Supplementary plan

As suggested, please find attached a revised copy of drawing B16f, with the soakaway reduced to 3 crates deep. I request that this drawing is uploaded to the planning portal and accepted as the agreed surface water design.

Drawing B16b August 2018 Scale 1:20 & 1:100 @ A1
Building Regulation Drawing - Externals Plan

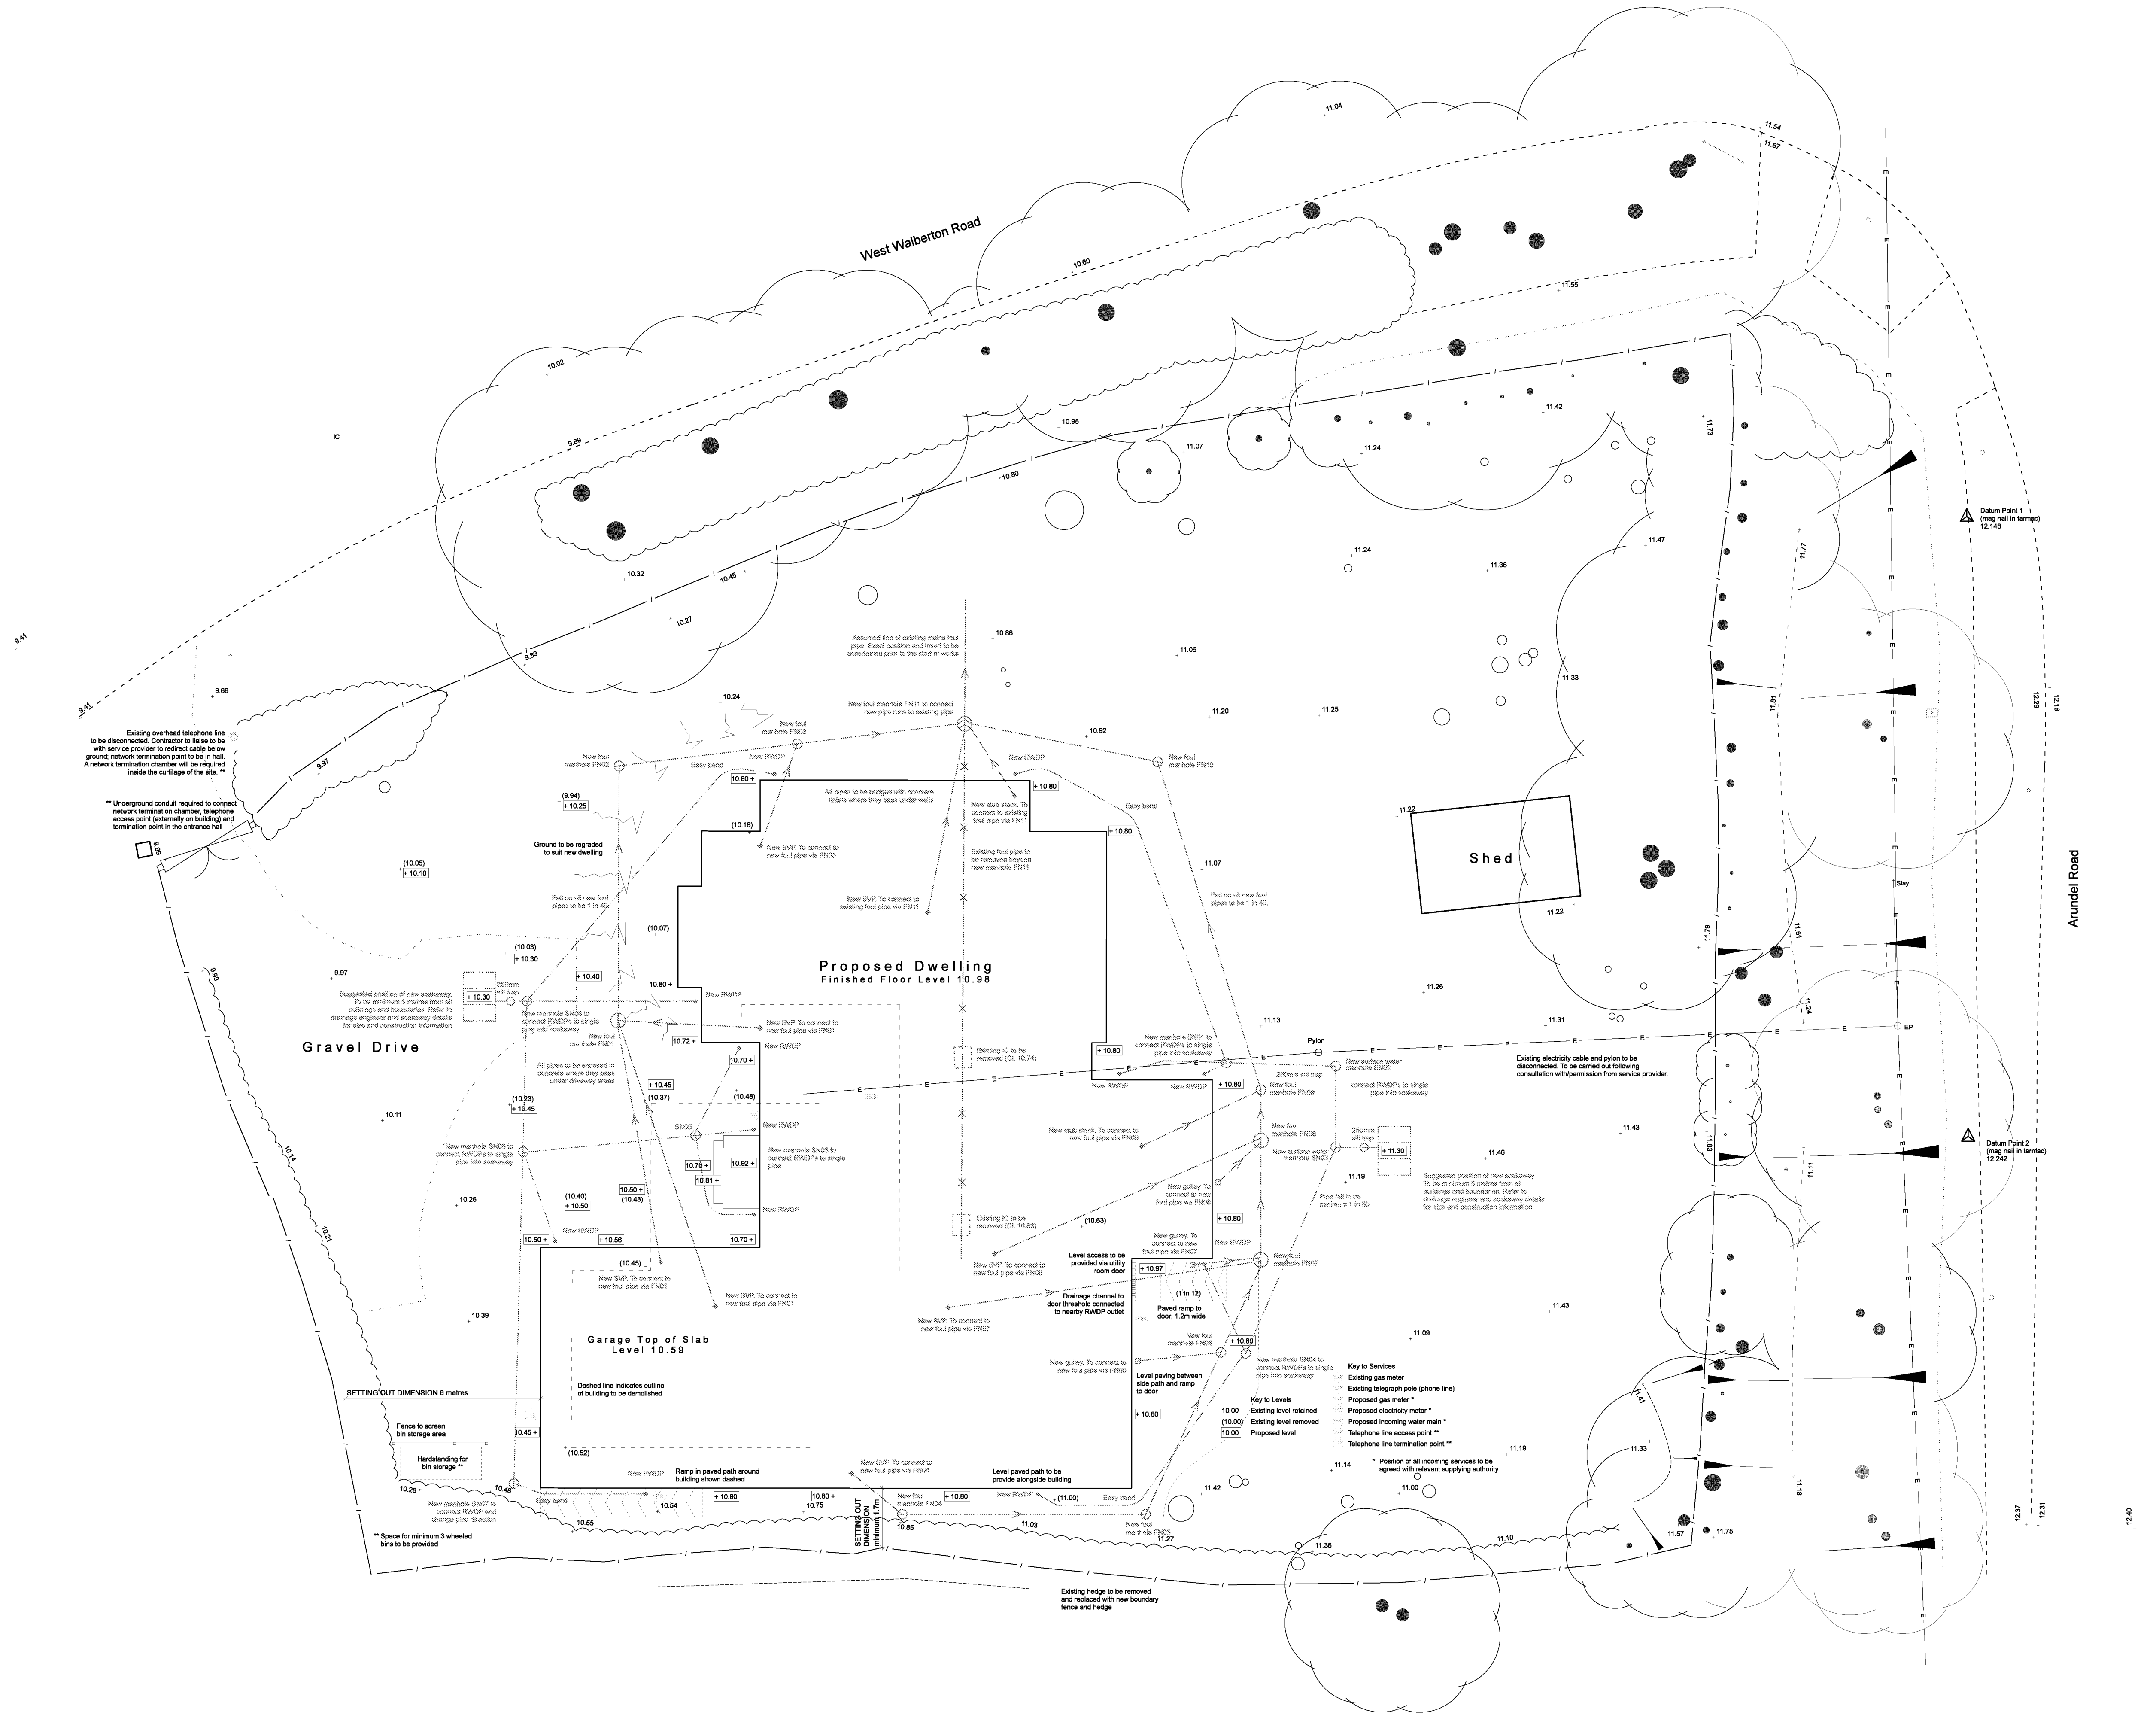
Thank you for the updated drawing. I appreciate that the extra level of crates have been included to compensate for the lower pipe level. However I am aware that this will provide a soakaway of capacity beyond design criteria which will result in additional expense to the applicant in excavation and materials. I am happy to accept this drawing and recommend removal of the condition, however if you supply a drawing with a soakaway of three crates depth I will also accept this. I asked simply that the pipe be raised to the highest point possible which I am happy that you have done.

Please let me know which option you would prefer, as long as it is clear which is proposed and the drawing and calculations are publicly available on the planning portal then I am happy for Laura's condition to be removed.

An additional layer of crates has been added to the soakaways to ensure that the invert is at least 1.2 metres below the incoming pipe.

I have looked at raising the level of the incoming pipes; the length of the longest incoming pipe to the rear soakaway is around 20 metres. At a fall of 1 in 80 and with minimum 300mm cover over the pipe, it is not possible to raise the level of the pipe where it joins the soakaway.

Whilst the fall and pipe lengths for the front soakaway would allow the incoming pipe to be at a similar level to the rear soakaway pipes, a minimum 710mm cover is required over the crates as they are positioned below the driveway. Therefore the best I can do is to raise the pipe to connect to the top of the highest crate, as shown on the amended details attached.
